Subject: Casita Vista Unit II Townhouses

RE: PLAT REVIEW - CASITA VISTA II

CASITA VISTA - UNIT TWO  
DRAINAGE MANAGEMENT PLAN

Reference: Casita Vista Development

CITY OF ALBUQUERQUE PUBLIC WORKS DEPARTMENT ENGINEERING DIVISION					
TITLE: GRADING & DRAINAGE PLAN (ALTERNATIVE A)					
APPROVALS	ENGINEER	DATE	APPROVALS	ENGINEER	DATE
City Engineer			Liquid Waste		
A.C.E.-Design			Traffic		
A.C.E.-Hydrology			Water		
DRAWING NO.			SHEET 1 OF 2

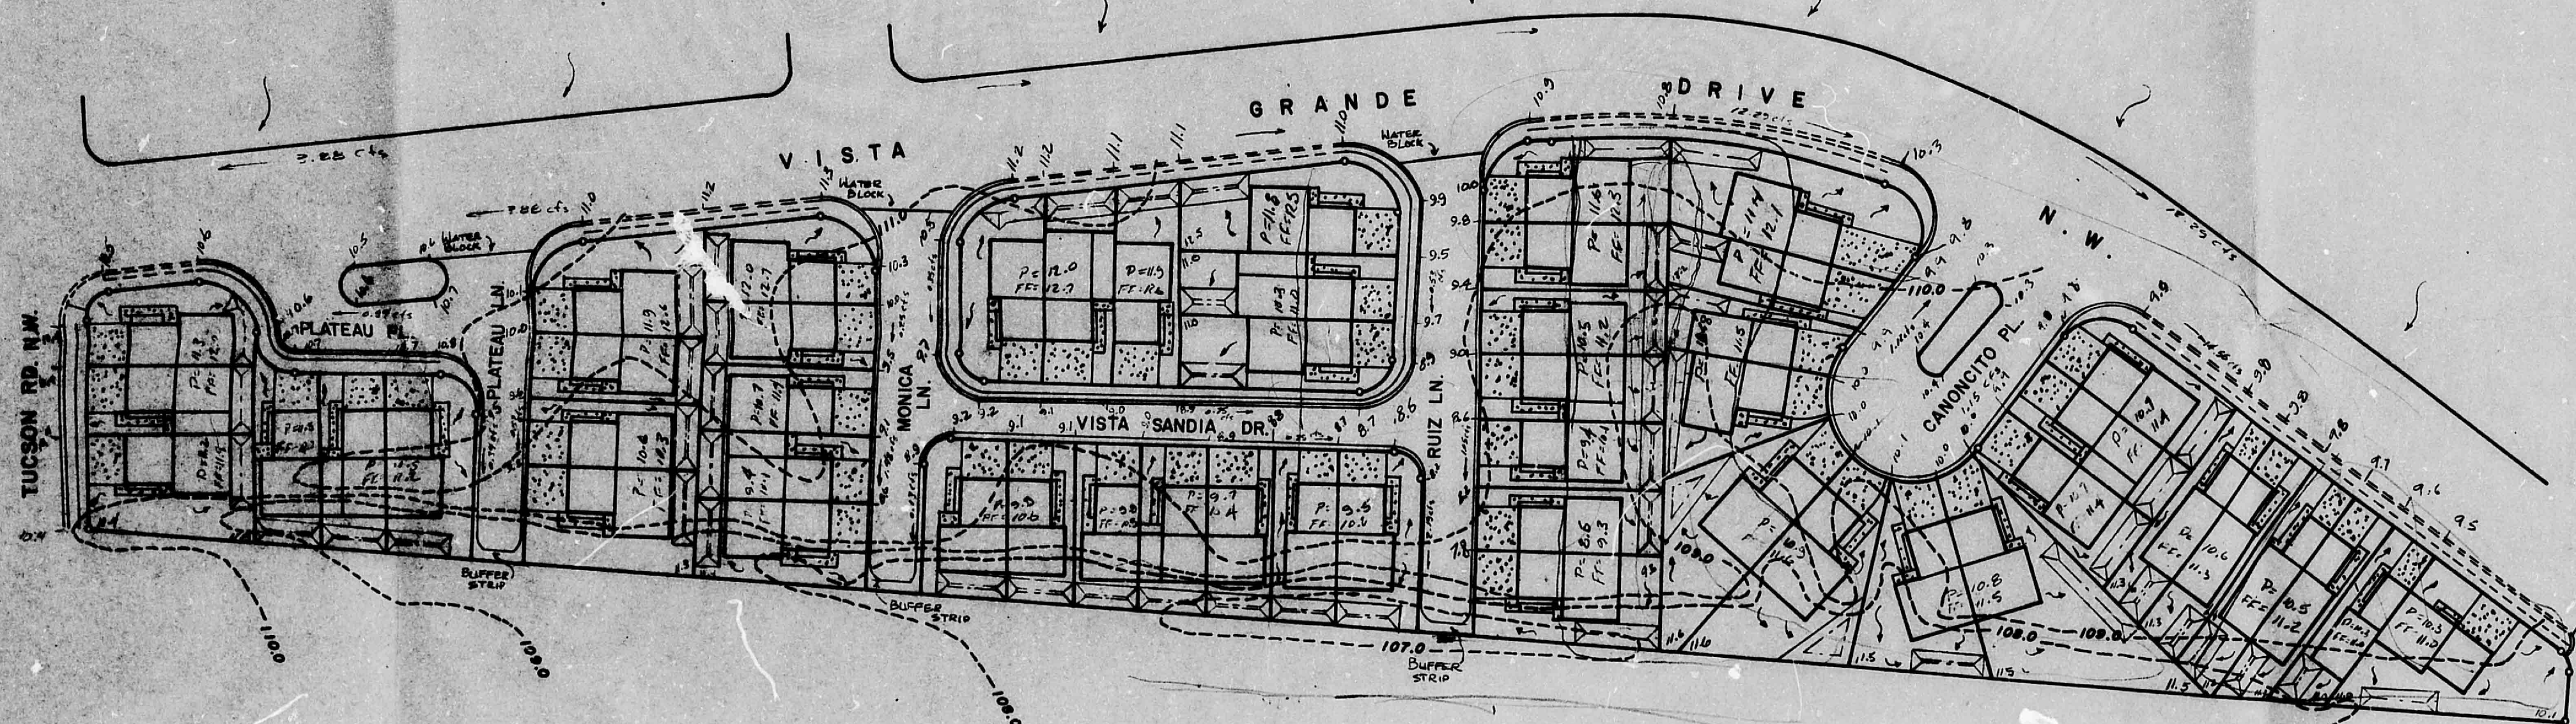
A field investigation has revealed that the soil in place is mostly loose alluvial sand with much greater permeability than that exhibited by the soils of the east alluvial fans where a C value of 0.4 is usually adopted. I believe that the existing conditions do not warrant the use of a runoff coefficient C greater than 0.15-0.2.

I also object to the proposal of raising the land by importing fill material and conveying the developed runoff to 52nd Street. The minimal nature of the storm drainage facilities in the valley makes it imperative that no additional discharge be conveyed to already overload facilities, or preempt some of their capacity. My Assistant, Fred Aguirre, has reviewed the computation submitted and found them inadequate (see attachment). I concur with his disagreement, particularly with the use of a runoff coefficient of 0.65 for southwestern landscaping which is normally underlaid by polyethylene film; a value of 0.9 should instead be used.

I further find the drainage report inadequate in terms of the attention paid to the vertical bank, 10 to 15 ft. high, adjacent to the Arenal Canal: Will the ponding areas on top of the slope cause bank failures? A soil engineer report will be required to verify the stability of the slope with the design proposal submitted. Given the circumstances of the site, 100% retention is required. As you may be aware, the development plan shown on the drainage report is at variance with the plan submitted to the Planning Department, and a new action by the E.P.C., will be required. I am forwarding a copy of the plan to Mr. Don Peterson, for his review and follow up.

This letter will serve to assure the M.R.G.C.D. that only the rear and side yards of the proposed project drain into the ponds (which ultimately connect, hydraulically, to the M.R.G.C.D. facility) and there cannot be any grease or oil deposition resulting from irresponsible automotive use within the City Right-of-Way. As for the potential of an individual using the rear of the property for grease and oil dumping, I think that is highly improbable.

Firstly, the site is graded such that it would be physically difficult for any individual to drain their crankcase in the rear of the units, and secondly, the Covenants and the Site Development Plan call for a landscaping treatment in the rear yards (which may either be grass, southwestern landscaping or other vegetative cover). This landscaping should preclude any deleterious effect on your facility and obviate the need for a grease trap or other such construction.

The inlet of the six inch pipe which drains the ponds will have suitable protection over or above the orifice. We envision this protection to be hardware cloth or some other type of mesh but we will leave an opening to the contractor to suggest a more aesthetic alternative.

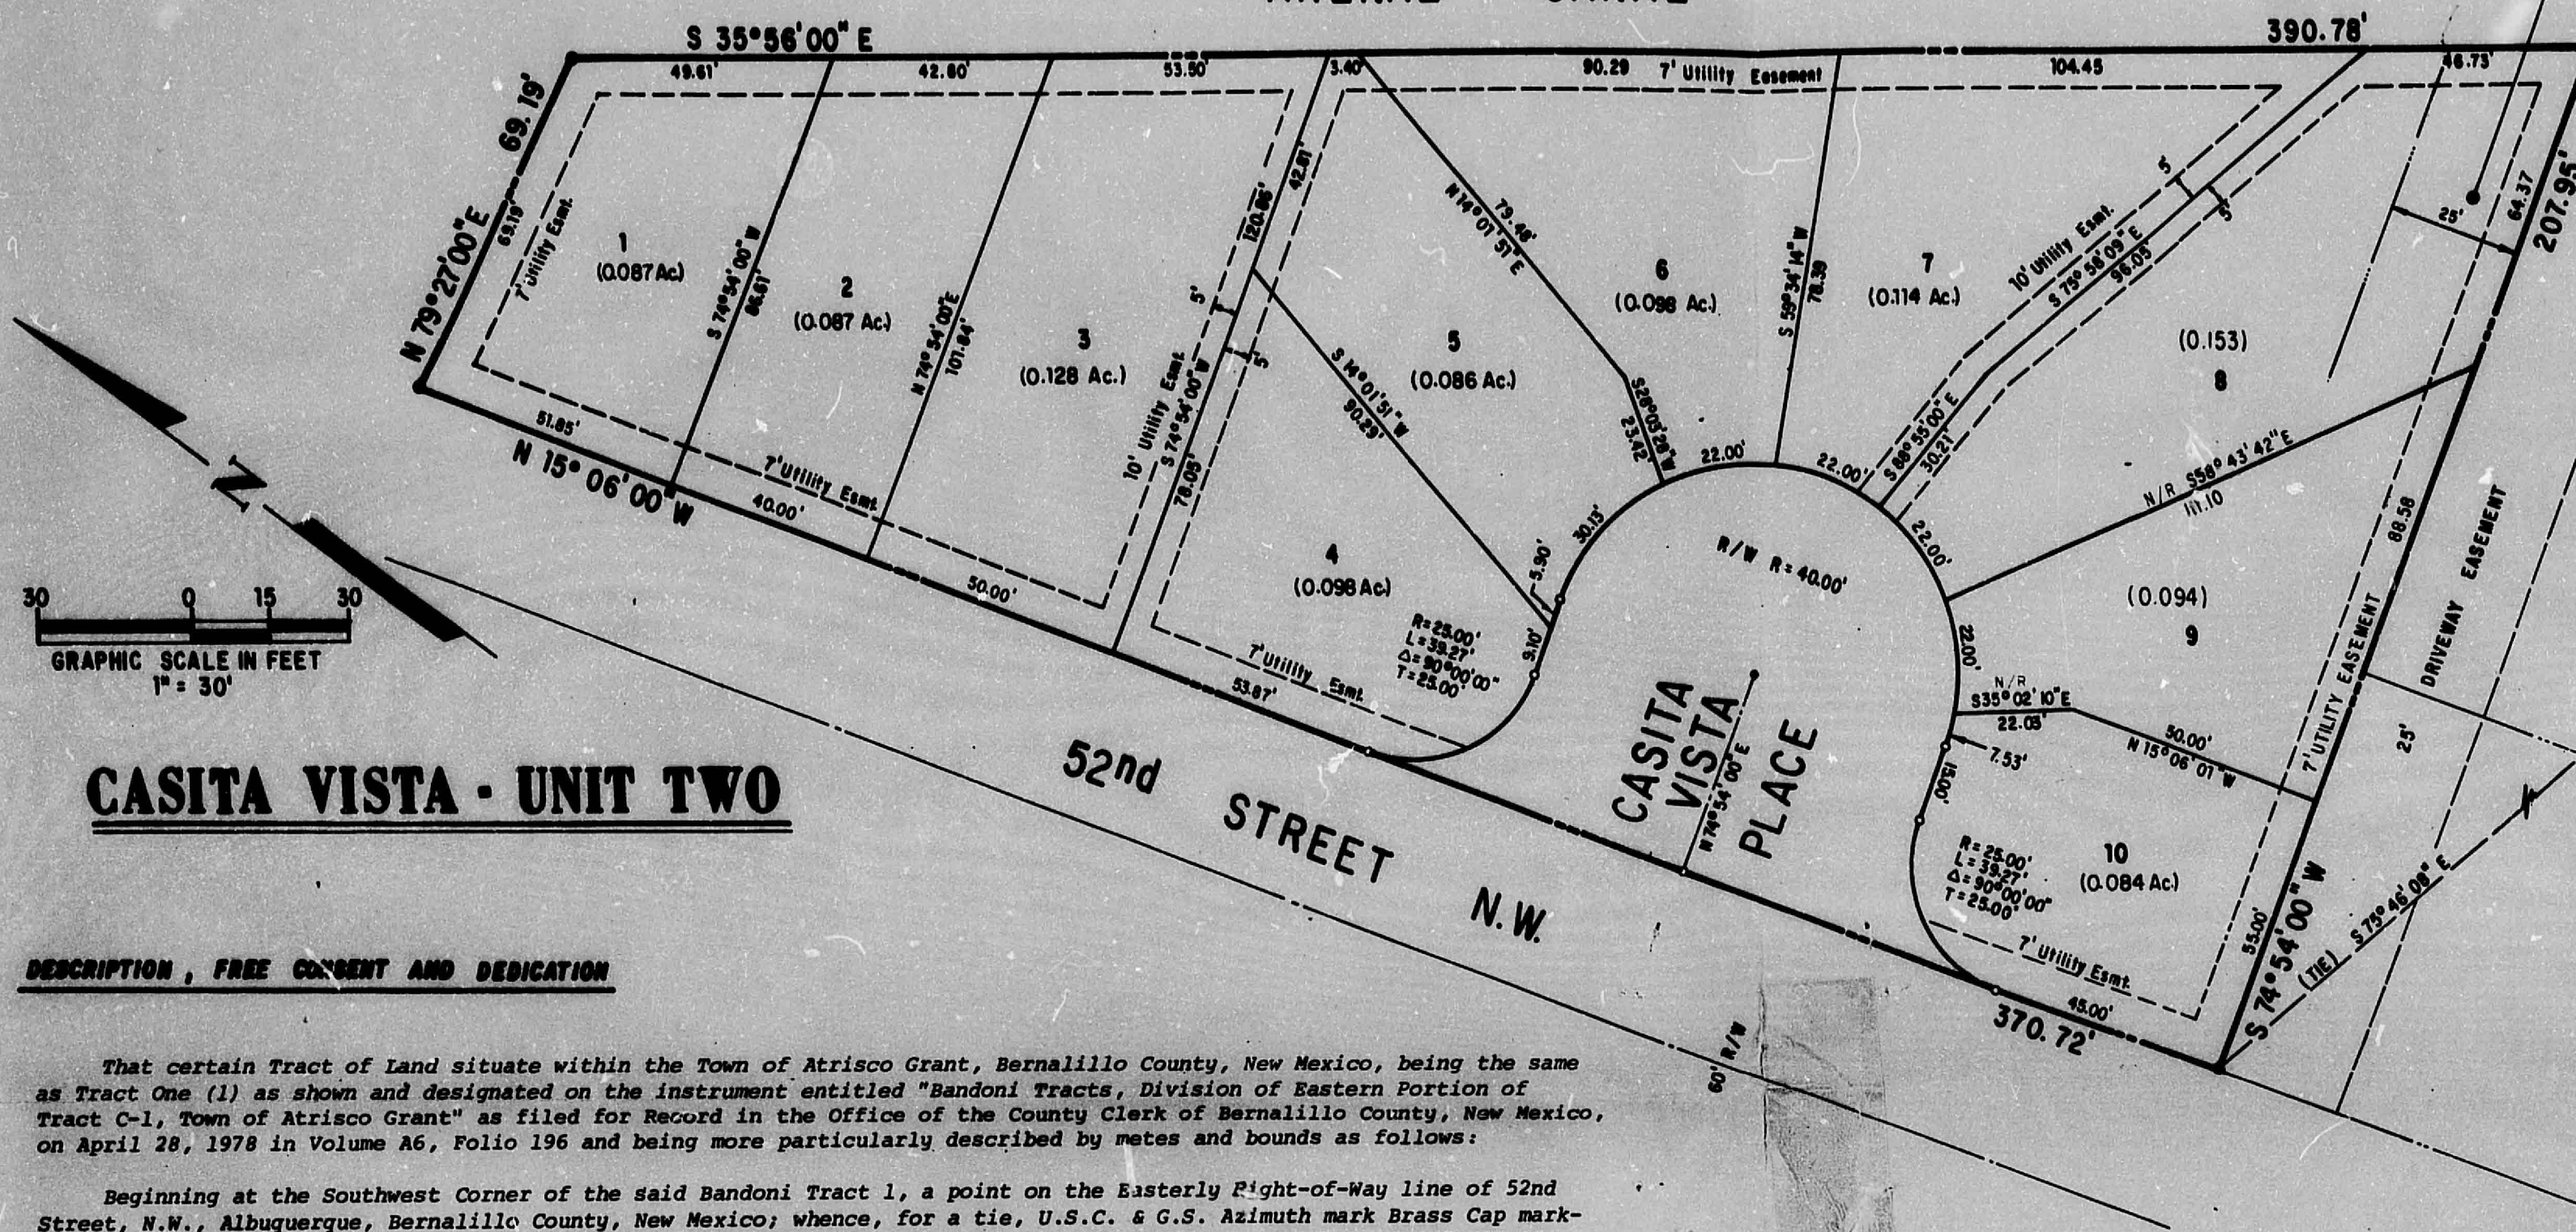
The above plat has been reviewed and only one deficiency is apparent. An easement or easements for drainage purposes should be dedicated between Casita Vista Place and the Arenal Canal should Casita Vista Place not drain to 52nd Street N.W. as previously discussed.
